The Millbrook Power (Gas Fired Power Station) Order

Explanation of Amendments Made to the Draft Development Consent Order and Other Documents – Submitted at Deadline 7

PINS Reference Number:	EN010068
Document Reference:	N/A
Regulation Number:	N/A
Author:	Pinsent Masons LLP

Title:
Rights of Way, Streets and Access Plan Key Plan
The Infrastructure Planning (Applications: Prescribed Forms and Procedure) Regulations 2009
Regulation 5(2)(k) Document Reference: 2.7

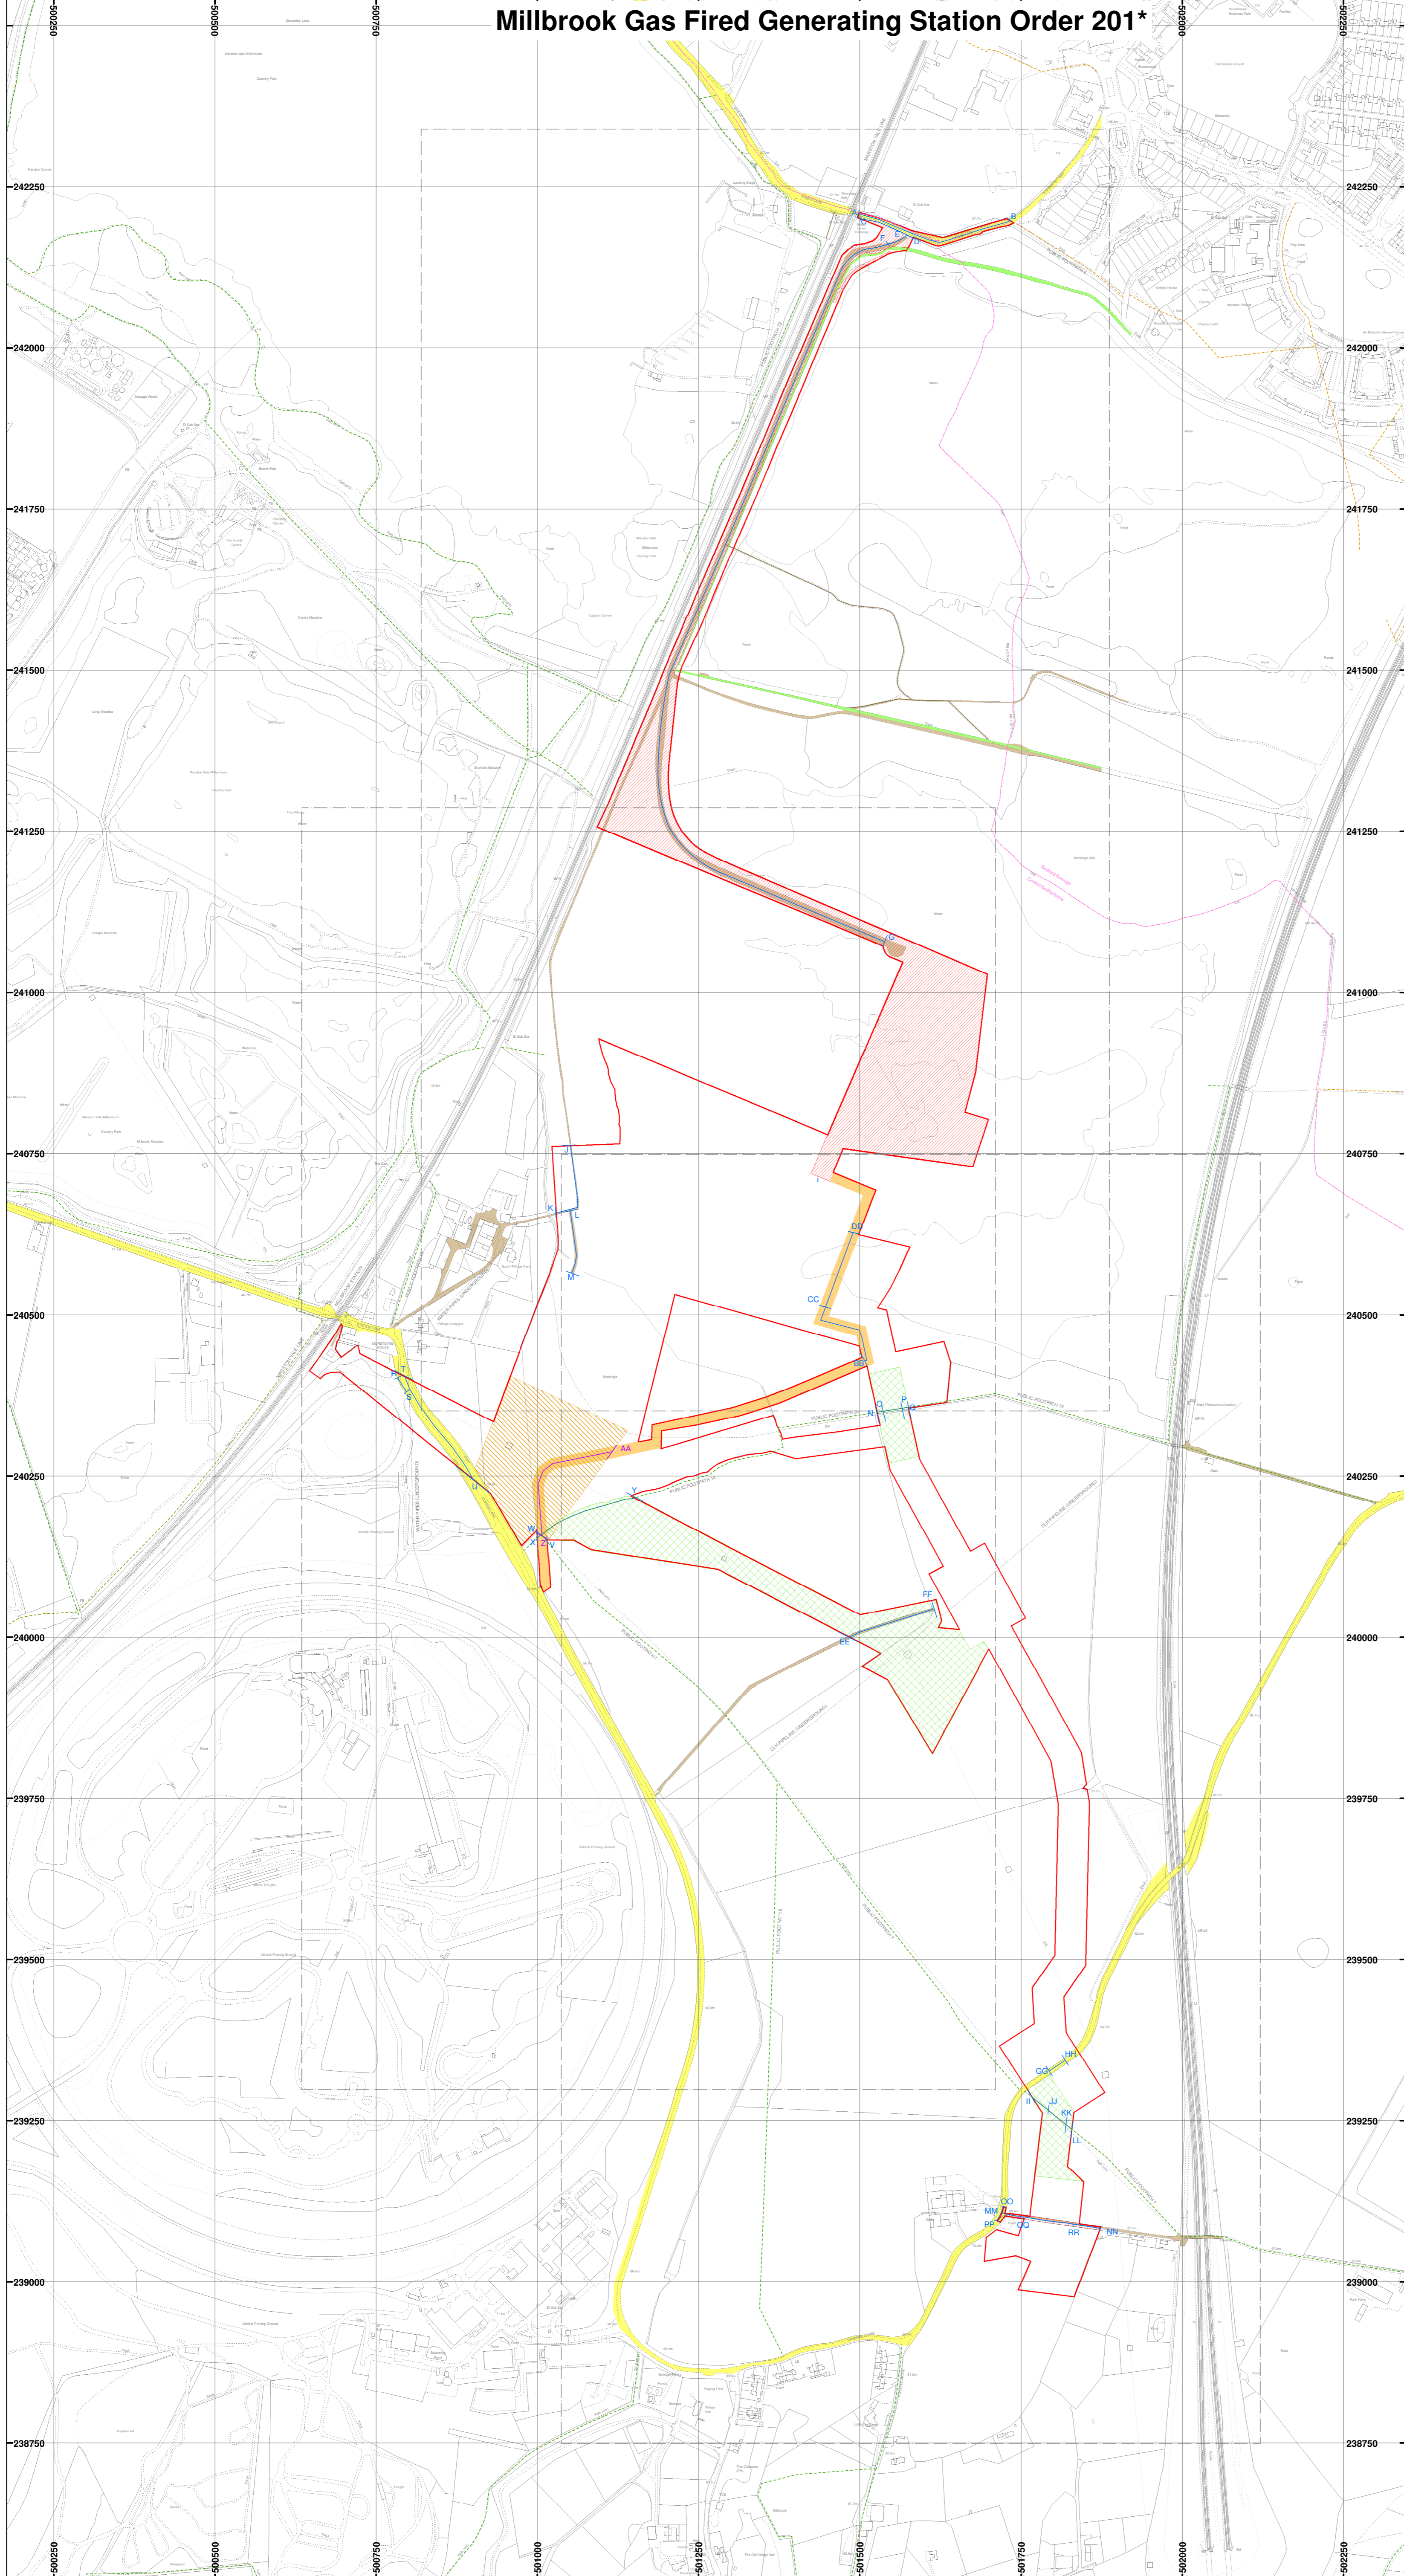
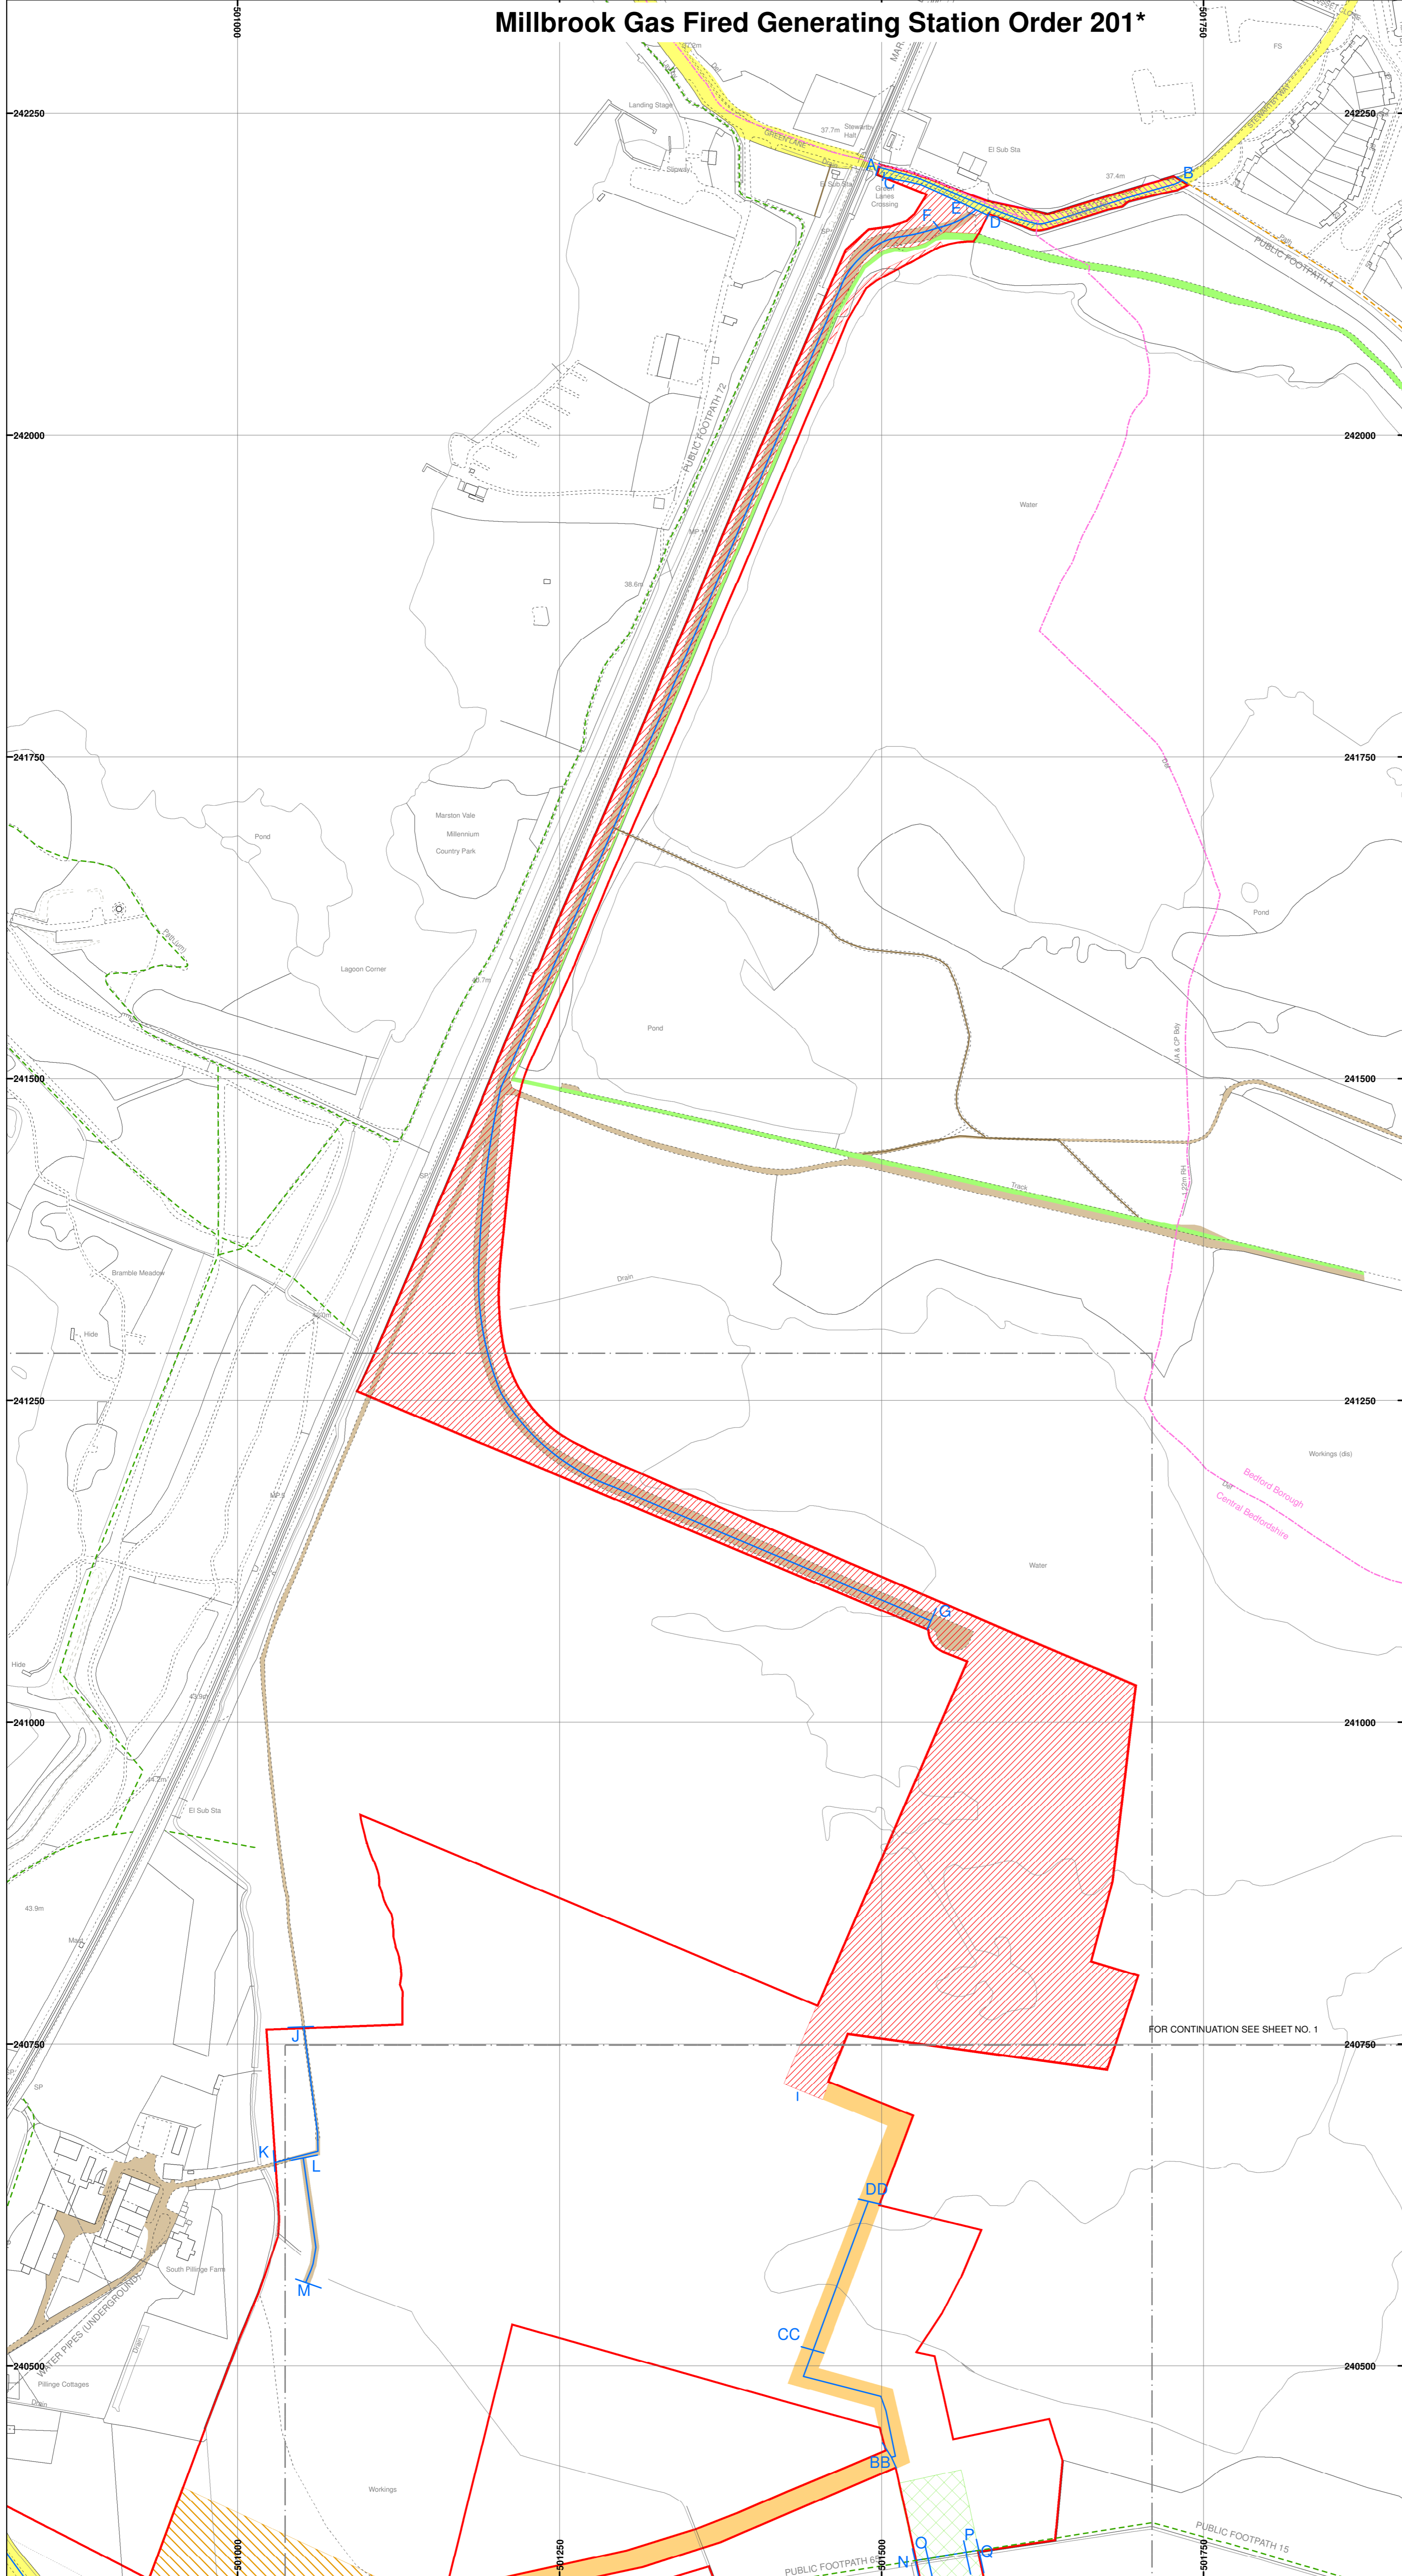
5.1 A minor change has been made to the Rights of Way Streets and Access Plan so that it now correctly refers to the "*Low Level Restoration Scheme Secondary Access Track*" instead of the "*Low Level Restoration Scheme Secondary Access Road*".
